Our reference: P-589671-B5X5
Contact: Sandra Fagan
Telephone: (02) 4732 7992

11 December 2023

**Council Response to Environmental Impact Statement - SSD-30871587
– Warehouse and Distribution Centre at 805–817 & Part 799–803 Mamre
Road, Kemps Creek, NSW, 2178**

Project	805 MAMRE ROAD KEMPS CREEK
Title	TURN PATHS PLAN SHEET 4

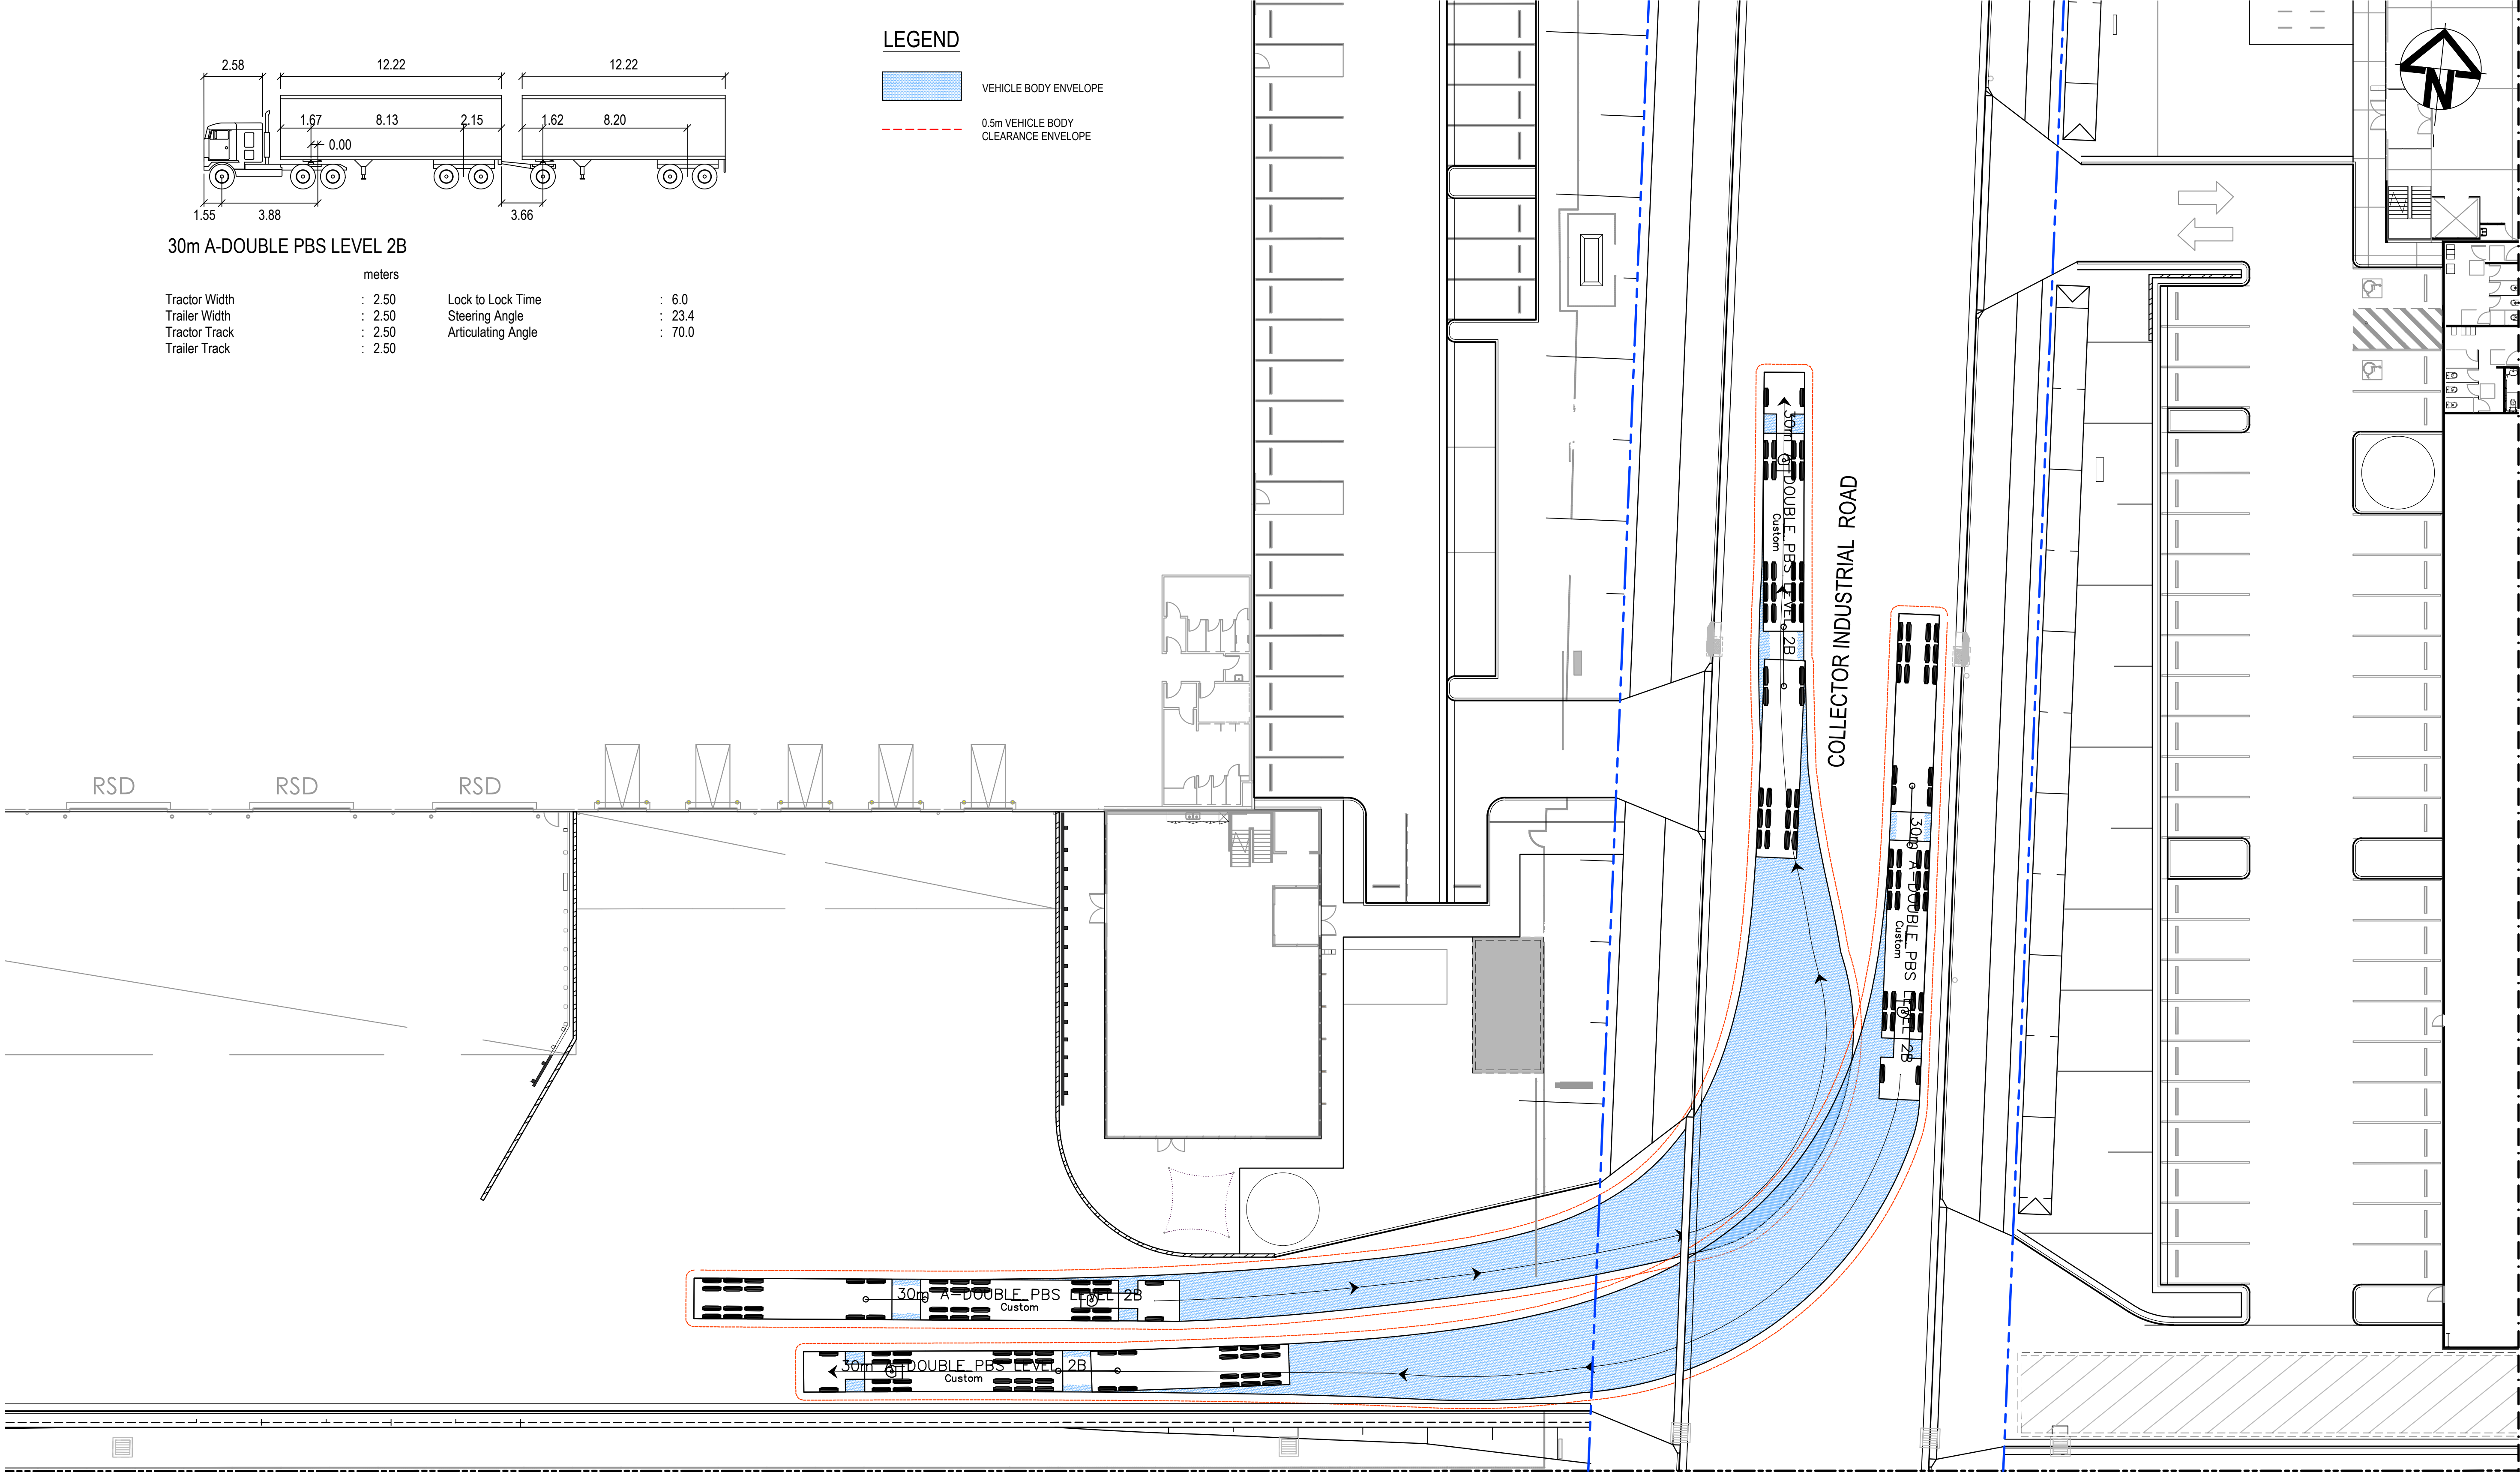
- e) The temporary access road is to be tested for a 36.5m PBS Level 3 Type A Vehicle, as this road will be operating functionally as a public road in the interim arrangement. Swept paths for this design vehicle are to be provided demonstrating adequate entry/exit to Mamre Road as well as entry/exit from temporary road onto the collector road.

Figure 3: Interim Site Access — Decommissioning Plan (Sheet 1)

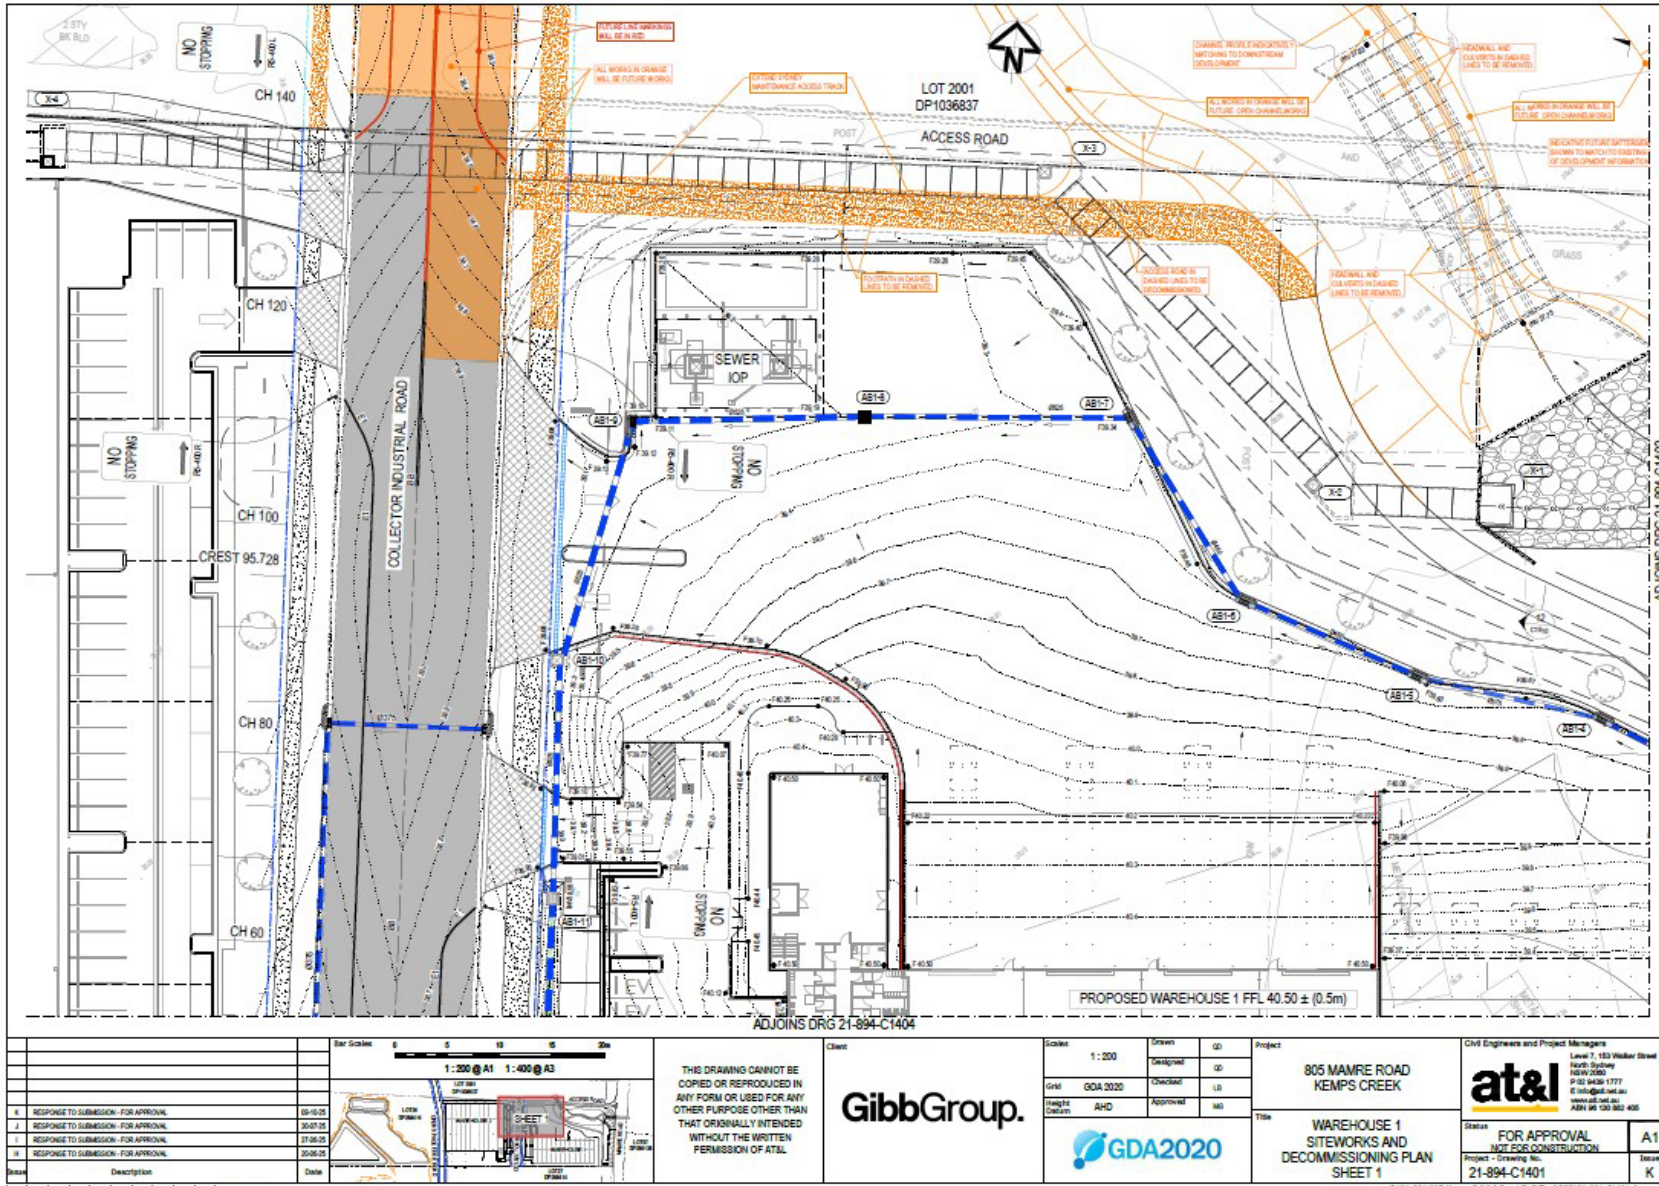
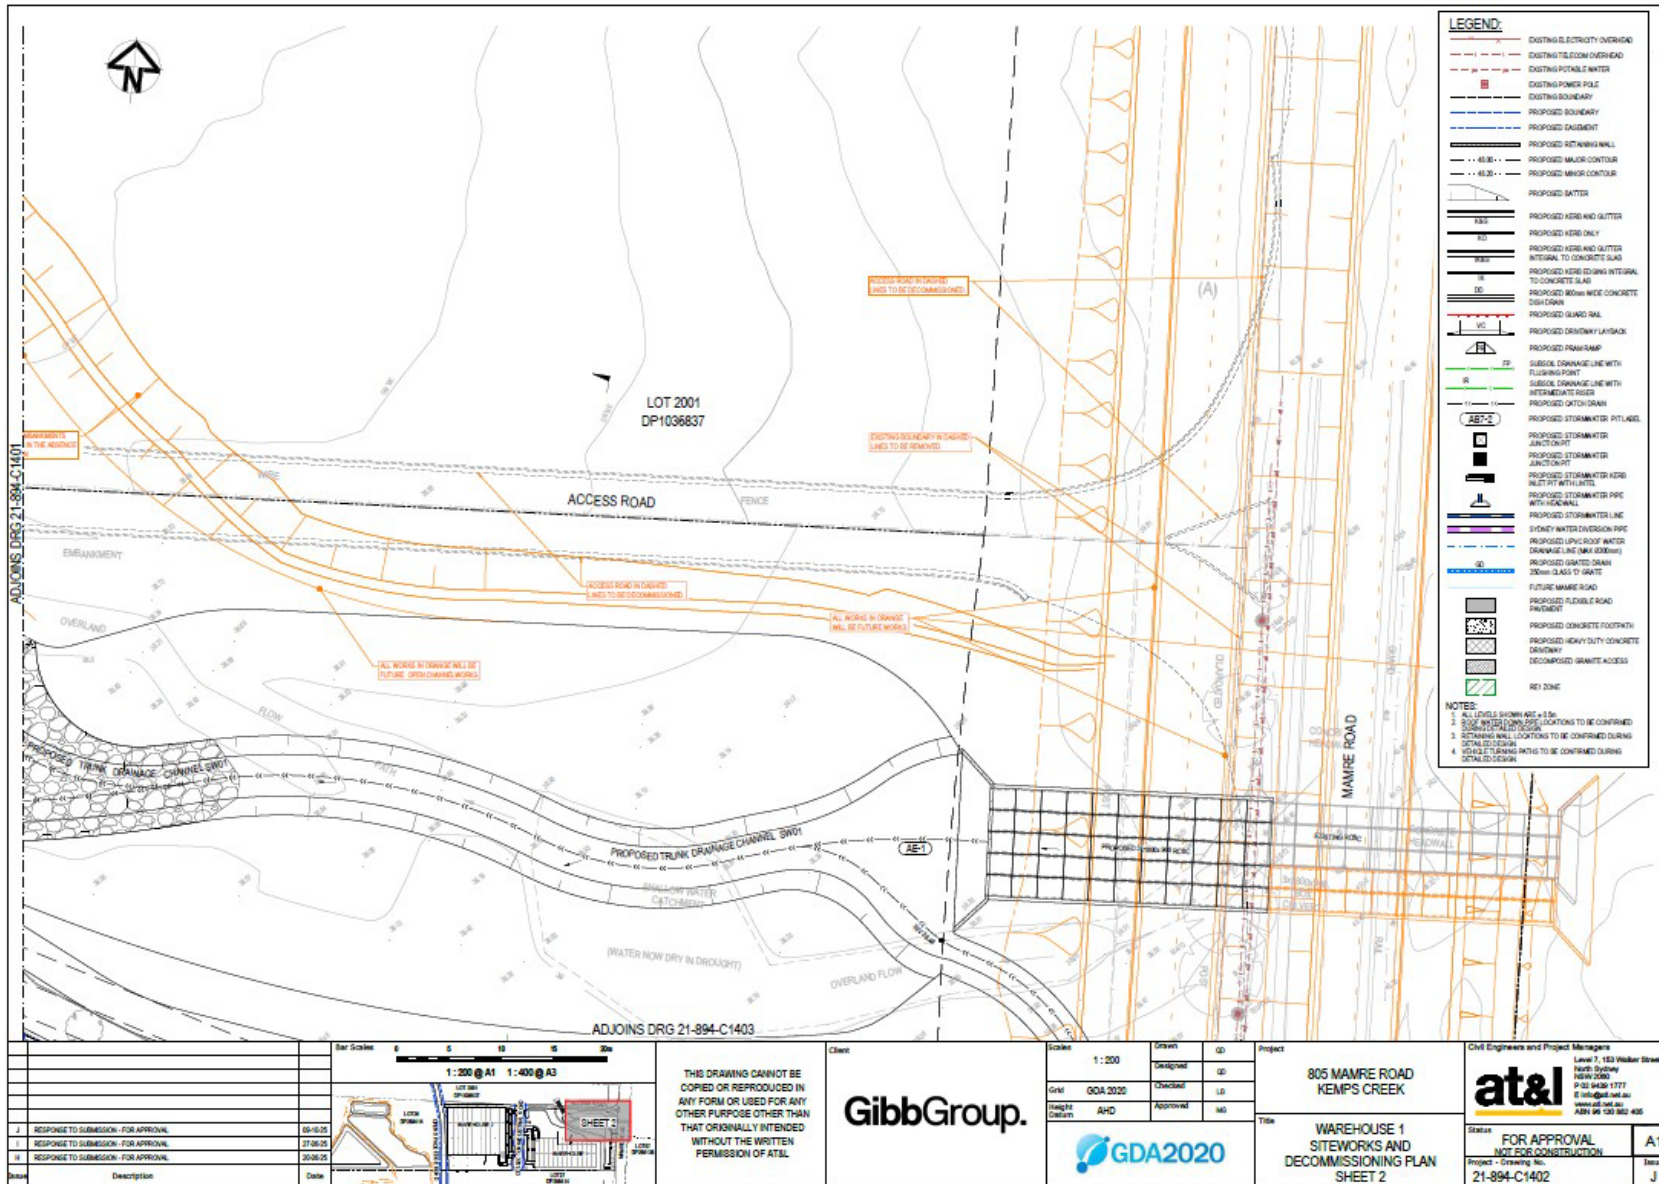
- b) Further engineering details of the post-development scenario with respect to decommissioning of the temporary access road to Mamre Road should be provided. Engineering plans/details showing removal of the culverts under this temporary access road and extension of the trunk drainage swale through to the adjoining property could be provided to this extent.

- c) The department should provide condition(s) to address this requirement (removal of this temporary access road).
- d) Provision needs to be provided on-site for errant vehicles that have entered the site. The use of private development to re-direct public traffic out of the site is not appropriate. A temporary cul-de-sac or other arrangement may need to be negotiated on the adjoining lot to facilitate manoeuvring out of the site in this interim arrangement.
